M E M O

Re: Project #1008256, 10EPC-40018, 10DRB-70268, SDP for Building Permit, Luna Lodge, Central Ave. NE

The site development plan was approved by the EPC on May 13, 2010, subject to 19 conditions.

**C1 SITE DEVELOPMENT PLAN**  
1" = 20'

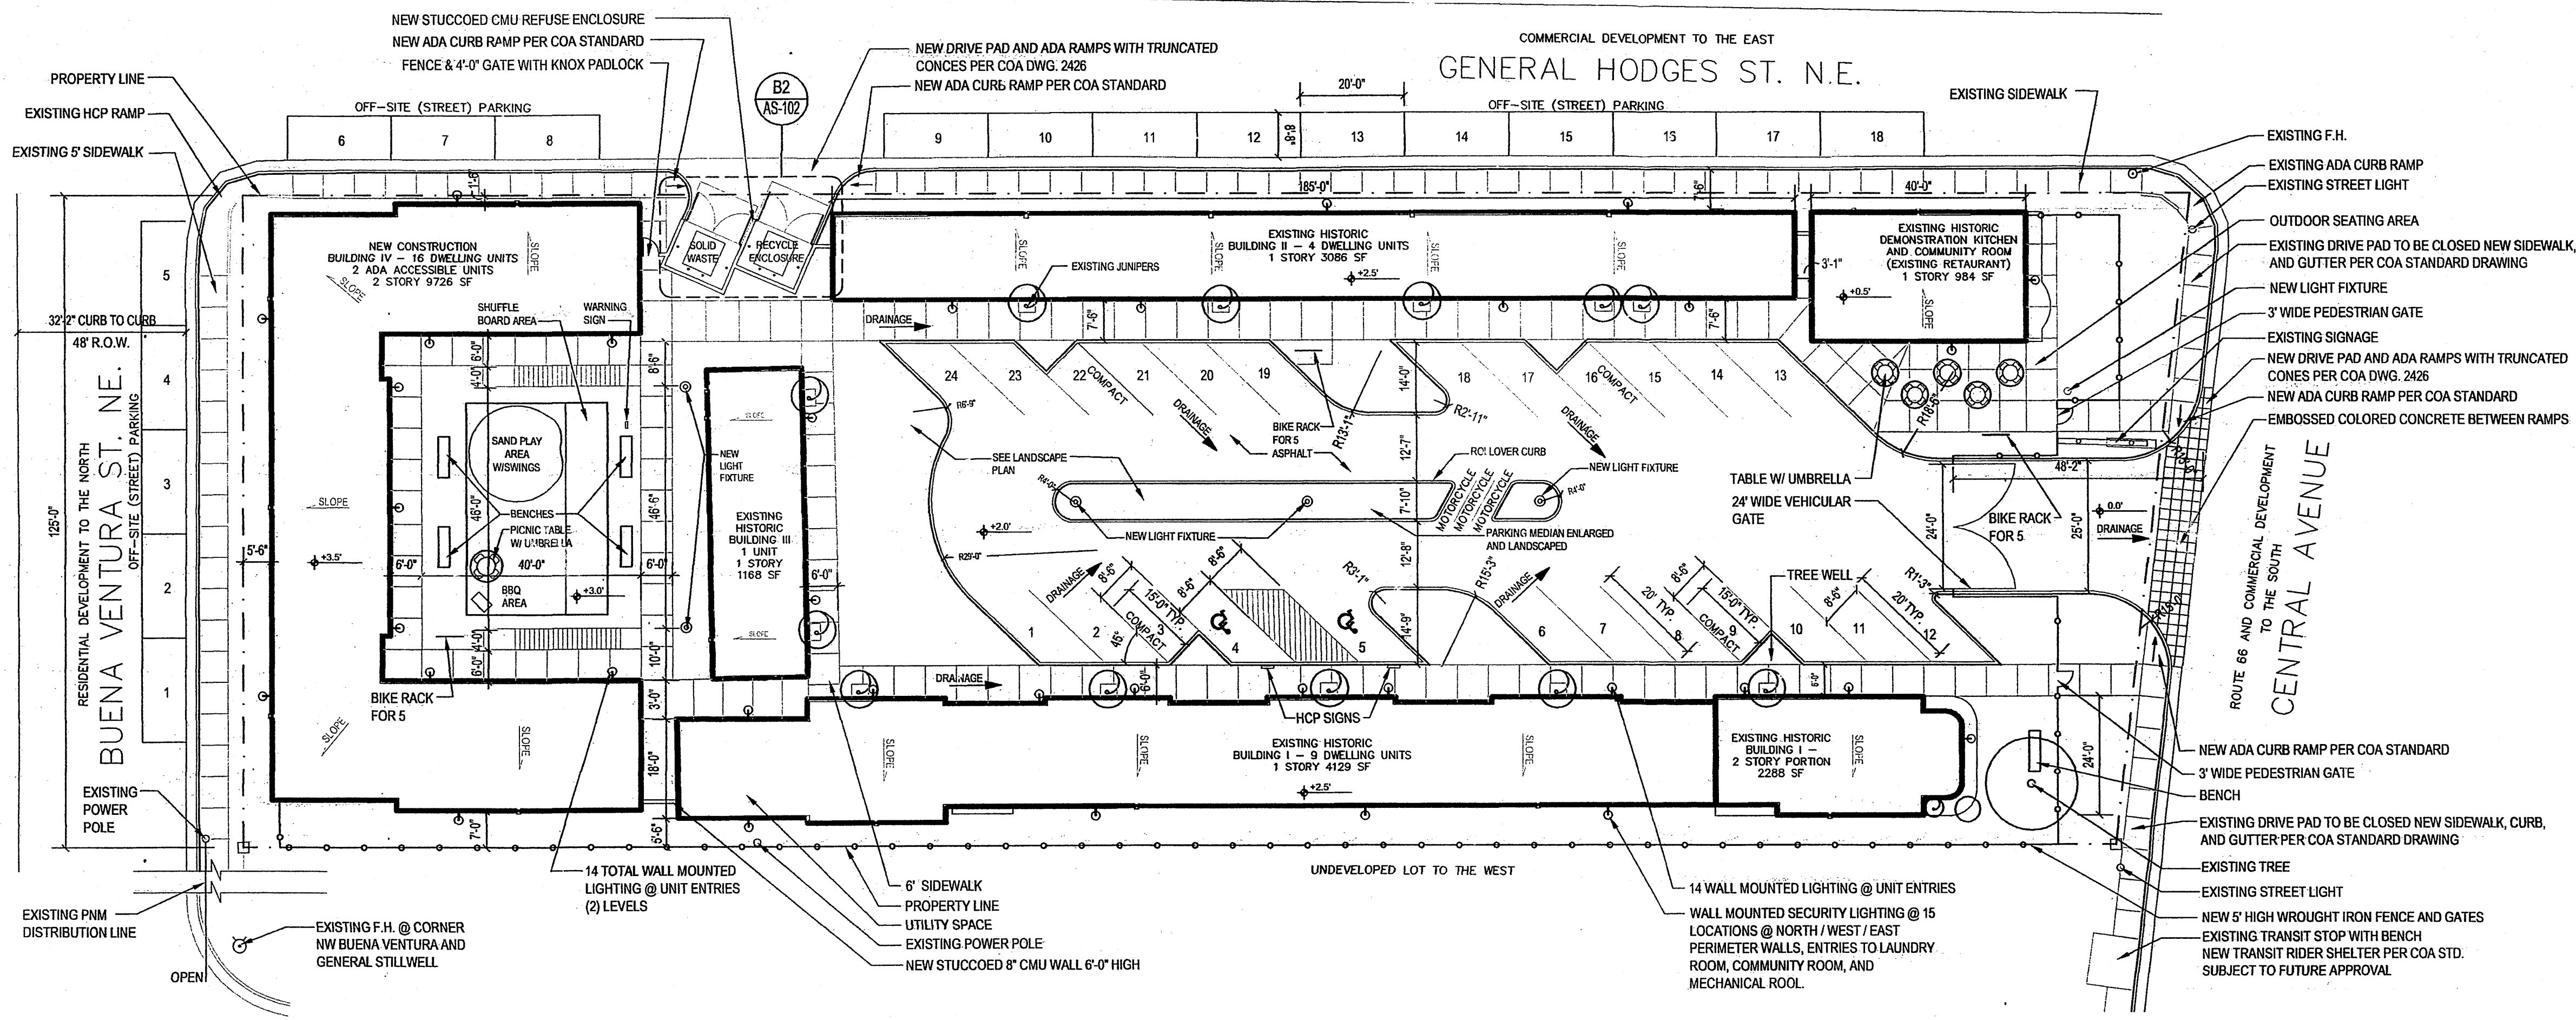
- 4.d The number of dwelling units with 1 bedroom and with 2 bedroom shall be added.
- 8. The curb returns at the site drive shall be tightened to ensure motorists slow down before entering or exiting the site and thereby improve pedestrian safety, per the intent of the EPC.
- 11. The location of the bike rack at the east of the site drive shall be adjusted to maintain a 6' clear pedestrian path.
- 14.i The provided landscape area shall be amended to reflect 3,000 sf of usable outdoor area, and the live vegetative cover calculations shall be amended accordingly.

- the pedestrian path east of the site drive shall be adjusted to meet the sidewalk on Central instead of the ADA ramp.
- the shuffleboard area in the new courtyard shall be deleted.
- a note shall be added stating that the location of the wrought iron fence along the Central frontage is subject to historic preservation requirements.

Staff has discussed these outstanding issues with the applicant's architect and agent. Staff agreed that the changes to the site plan (AS-101) can be made manually on the mylar and that a revised landscape plan (L1) will be submitted to the DRB.
